From: Jean Fraser
To: Latulippe, David
CC: chewett@hwengineers.com; dcm.danmiller@gmail.com
Date: 7/31/2015 3:49 PM
Subject: Re: Fwd: Marginal Way - Photometrics
Attachments: ES101-SitePhotometric_3.pdf; Section 12 - Site Lighting_8.4.11.pdf

Its much better for the drive through area (it exceeds our max of 20 fc by a bit but I am OK with that at this location) but since our max is 0.1 fc at the property line (re trespass) and this has 1.5 to 1.7fc its difficult to waive it when its so much over the max- I agree this location merits more lighting and will support a waiver, but could the poles be lowered or other minor change made to reduce more of these boundary levels to under 1.0 fc especially along the east side?

SHEET TITLE
**ELECTRICAL SITE
PHOTOMETRIC PLAN**

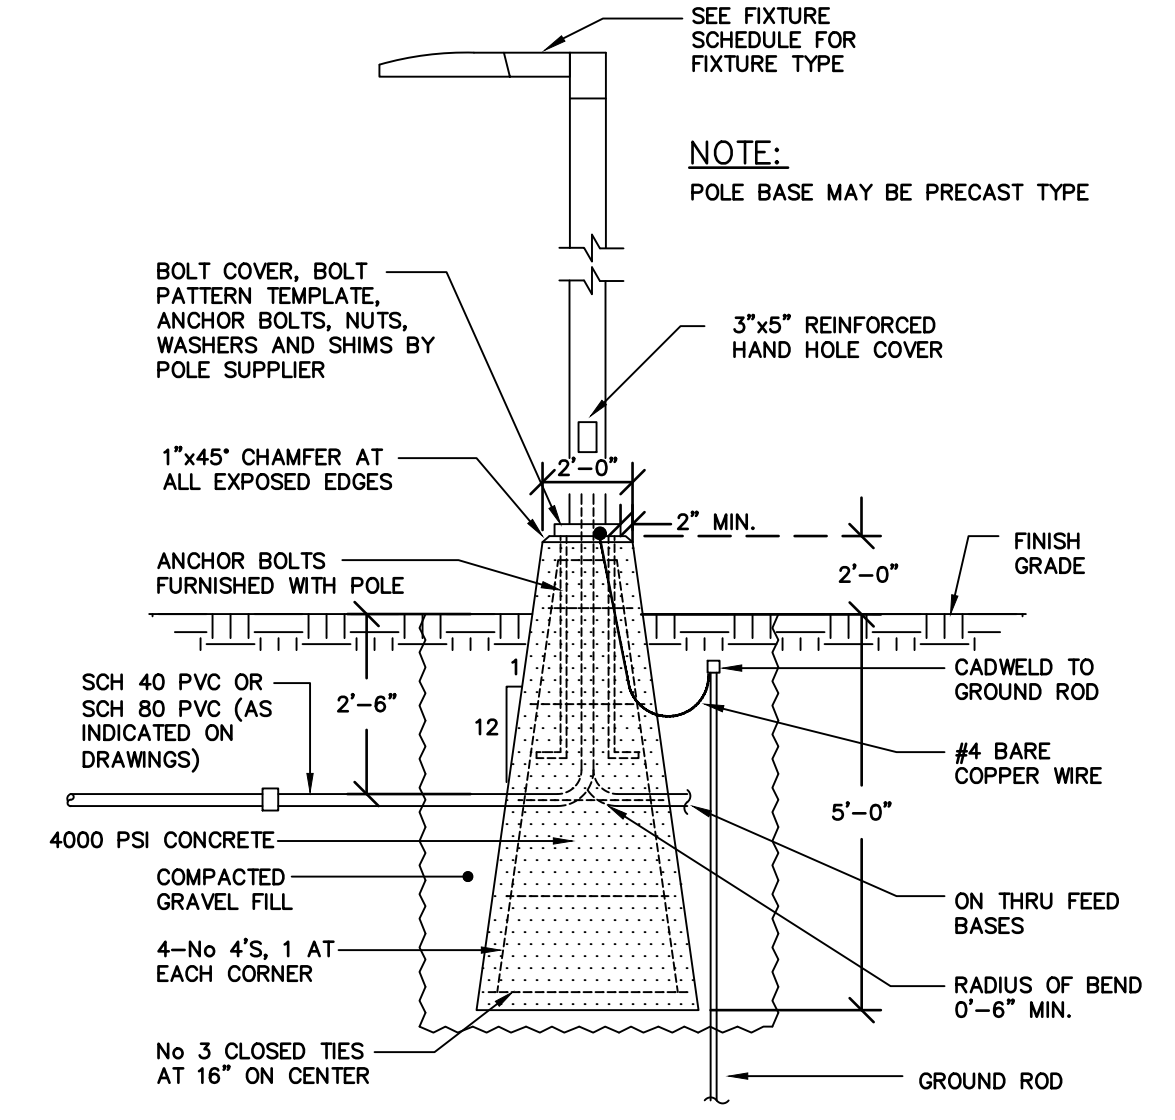
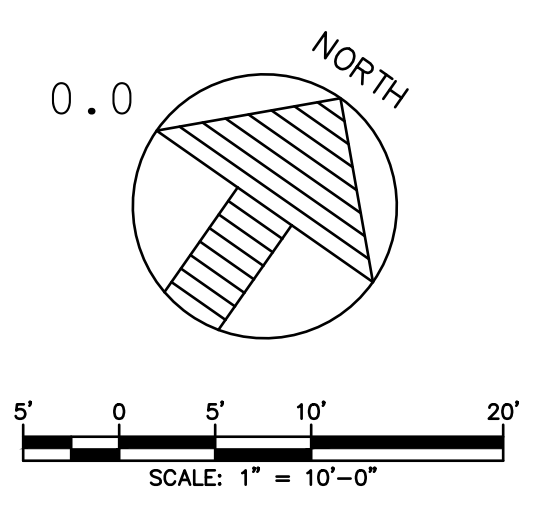
Also I would like to see the lighting spec (as stated in the condition) to confirm that its a cut off type lamp.

Attached is the revised Photometric plan. I simply relocated the fixtures a few feet to try accomplish what we need.
